WELWYN HATFIELD COUNCIL – DEVELOPMENT CONTROL
DELEGATED REPORT

APPLICATION No:	S6/2007/1368/MA
------------------------	------------------------

The site for this application has an area of 2.7ha and has vehicular access from the existing roundabout on Mosquito Way. The proposal is a reserved matters application for 164 dwellings, and includes access roads, car parking and open space. A previous application for a similar development (ref: S6/2007/611/MA) was withdrawn in June 2007. The applicants also submitted an application for the Phase 4 infrastructure roads only (ref: S6/2007/1338/MA), which was refused on 6/12/07.

Drawing Title
 2+ Bed Private Apartments (Premium type)
 GA Elevations
 SITE PLAN BUILDING TYPE H

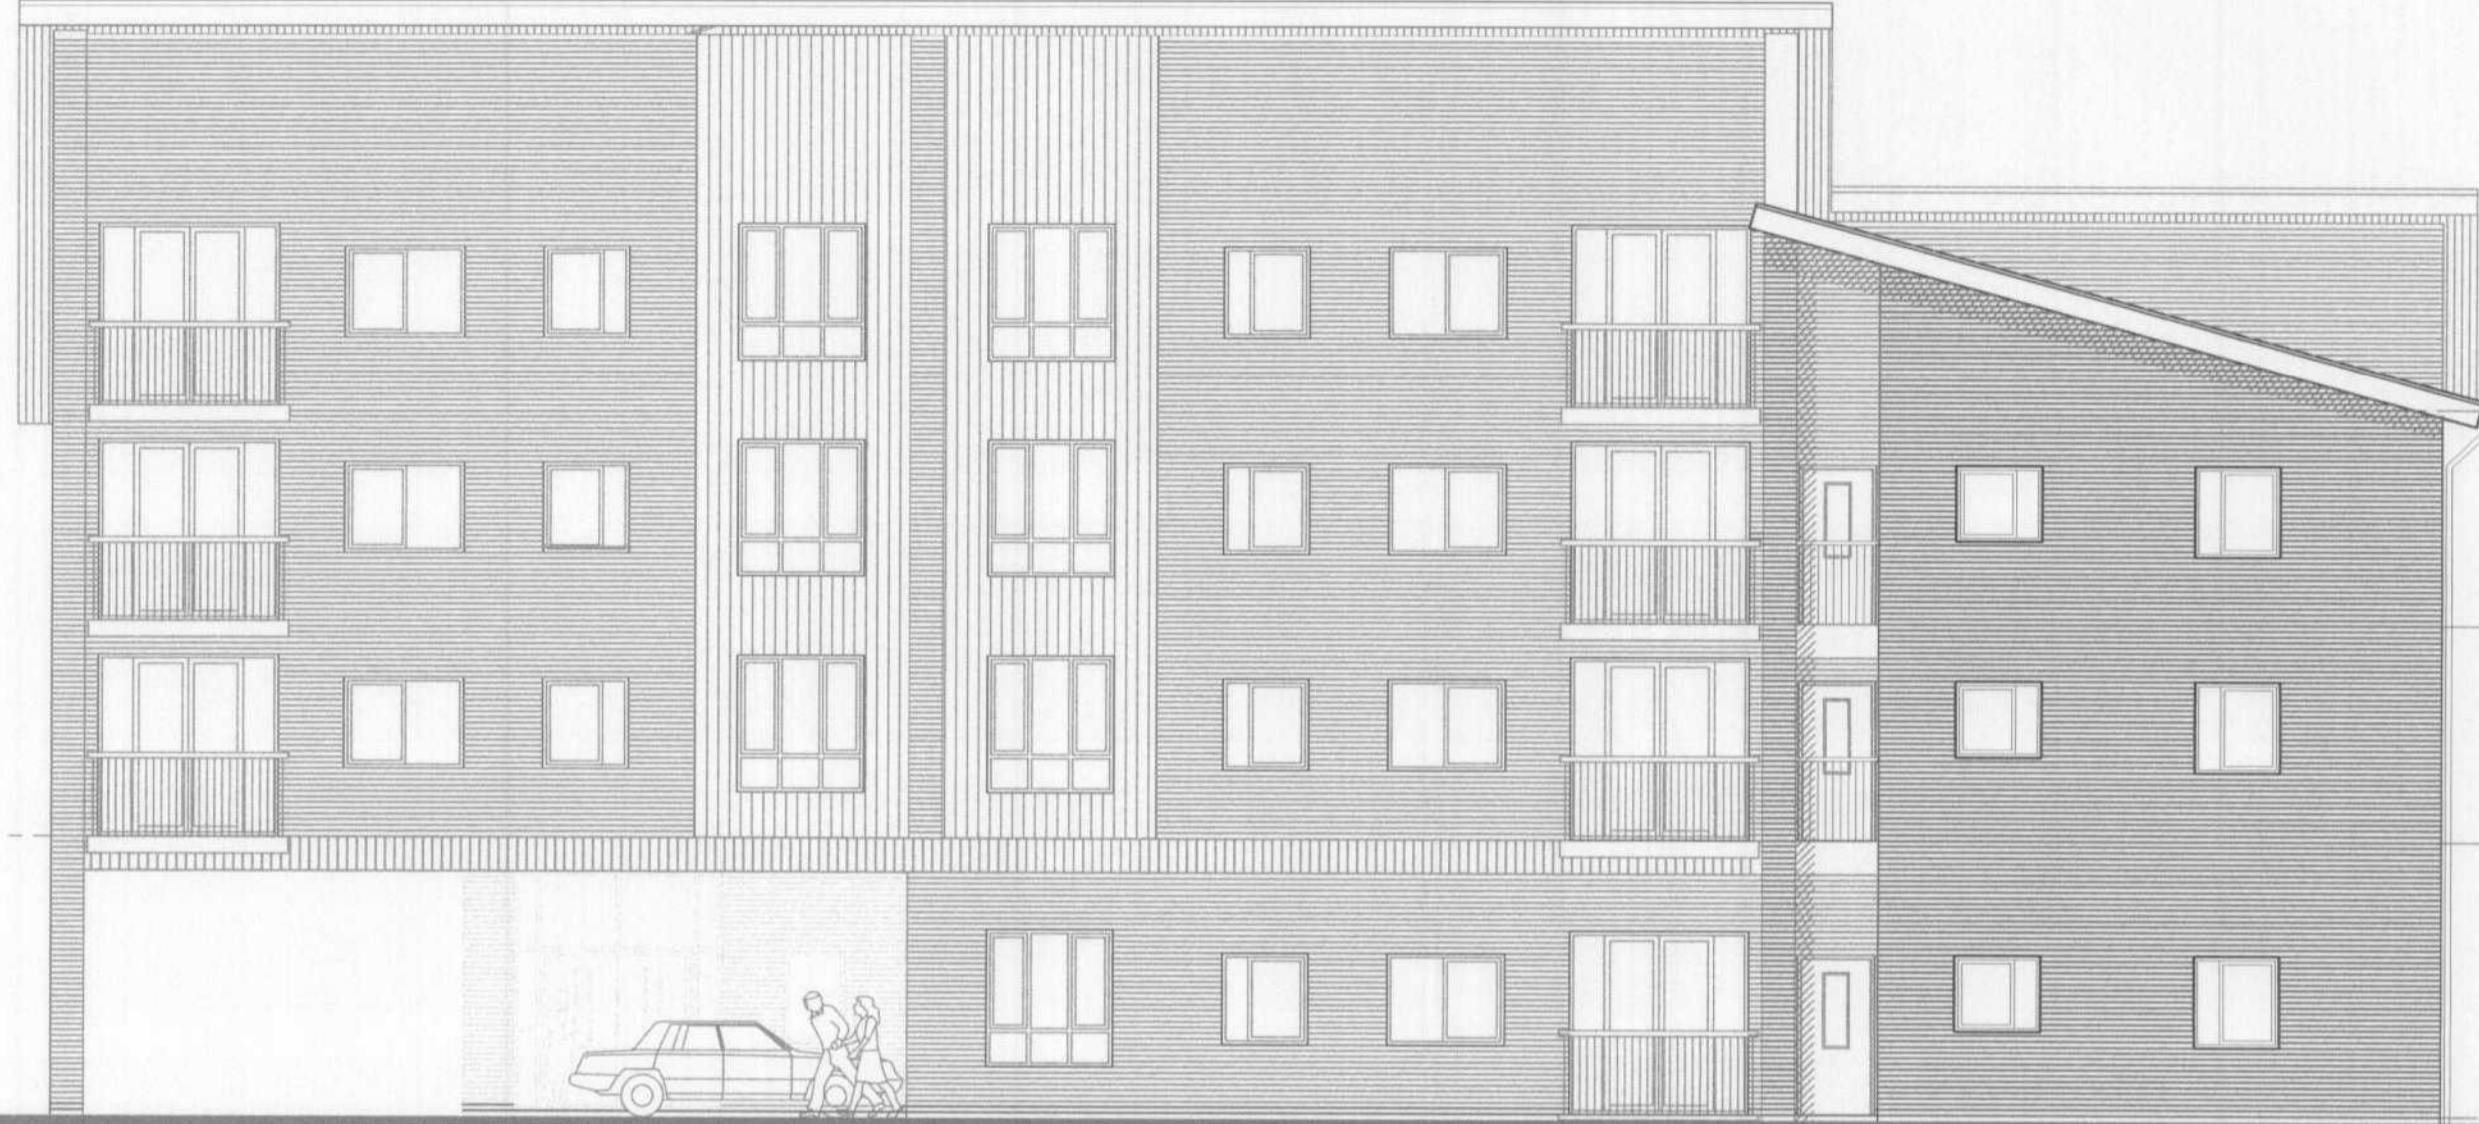
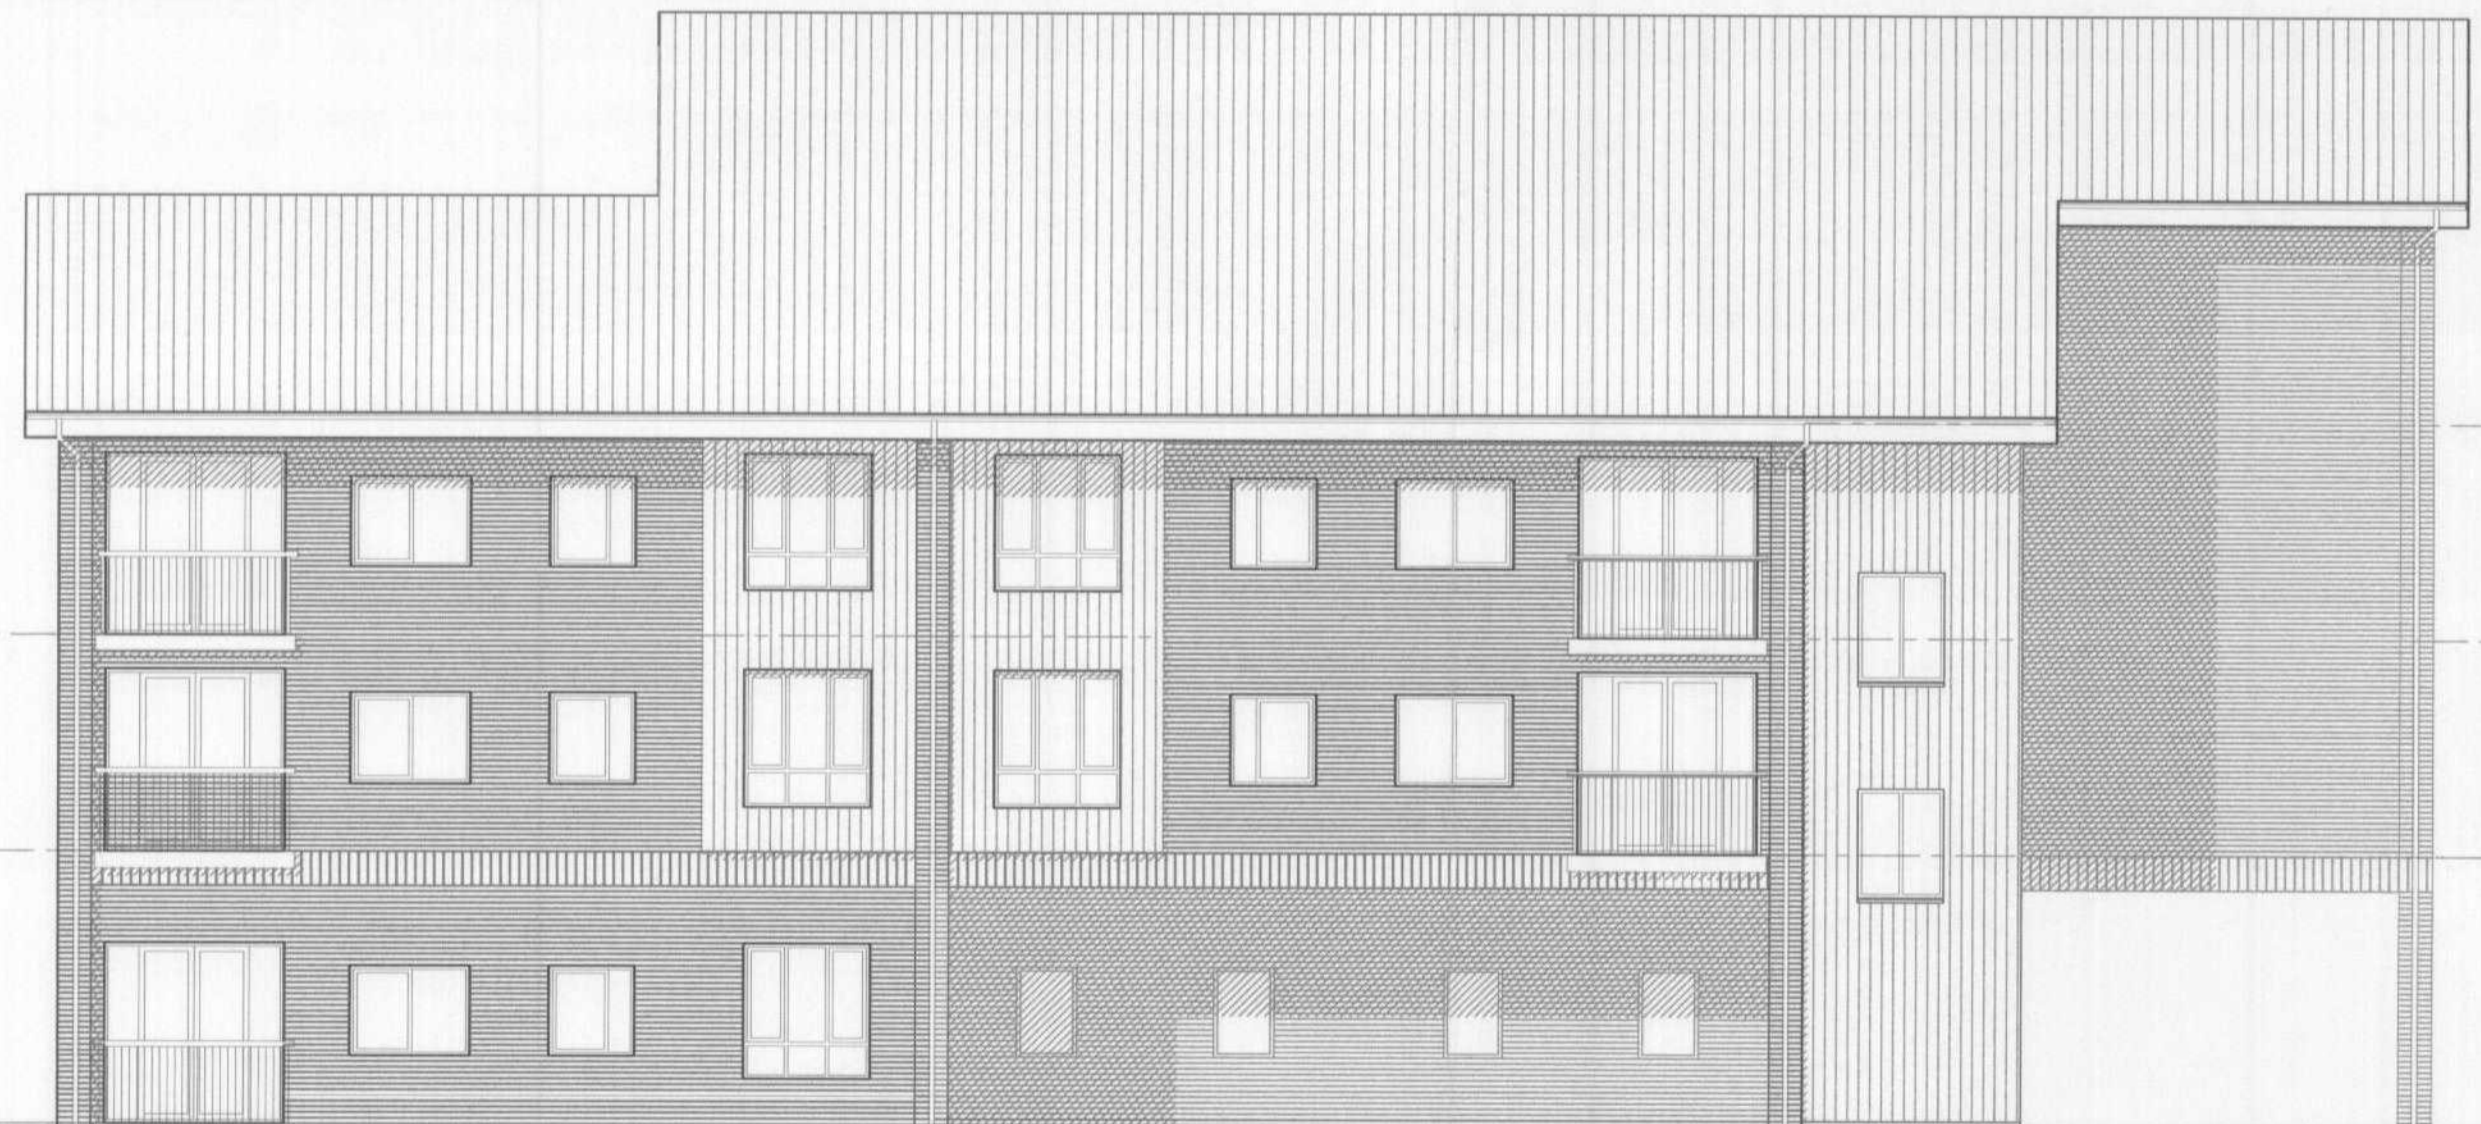
The Mosquito Way frontage is more successful, but is compromised by the lack of a distinct entrance statement at the junction of the internal access road with the roundabout. The narrow eastern projection of the site is acknowledged as challenging, but it is clear that Block H, which terminates the development, does not relate satisfactorily in terms of visual impact to the Clarkson Court flats, or provide a suitable transition to the heart of the District Centre beyond. Although there is a limited amount of car parking shown under the building, there is still an extensive surface parking area proposed for the eastern end of the site, which is visually unsatisfactory. The southern part of the site, to the rear of the properties fronting the shared surface, contains certain unresolved elements of 'left-over' space and two pairs of semi-detached units which are somewhat isolated and surrounded by rear boundary treatments.

The only direct impact of the proposed scheme on neighbouring residential occupiers is that of Block H on the occupiers of the nearest flat block in Clarkson Court. Inspection of the likely impact of the new block has taken place from both outside and inside the Clarkson Court flats. Because of the relative position and orientation of the two blocks, and the proximity of the northern projection of Block H to the Clarkson Court block (approximately 10m) I would take the view that this part of the development would have a significantly adverse effect on the amenity of some of the first, second and third floor flats in Clarkson Court by reason of loss of light and overbearing appearance.

2. The proposed Block H, through its height, massing and location, would have a significantly adverse effect on the residential amenity of the closest flats in Clarkson Court through loss of light and overbearing appearance, contrary to the provisions of the Supplementary Design Guidance to the Welwyn Hatfield District Plan 2005.
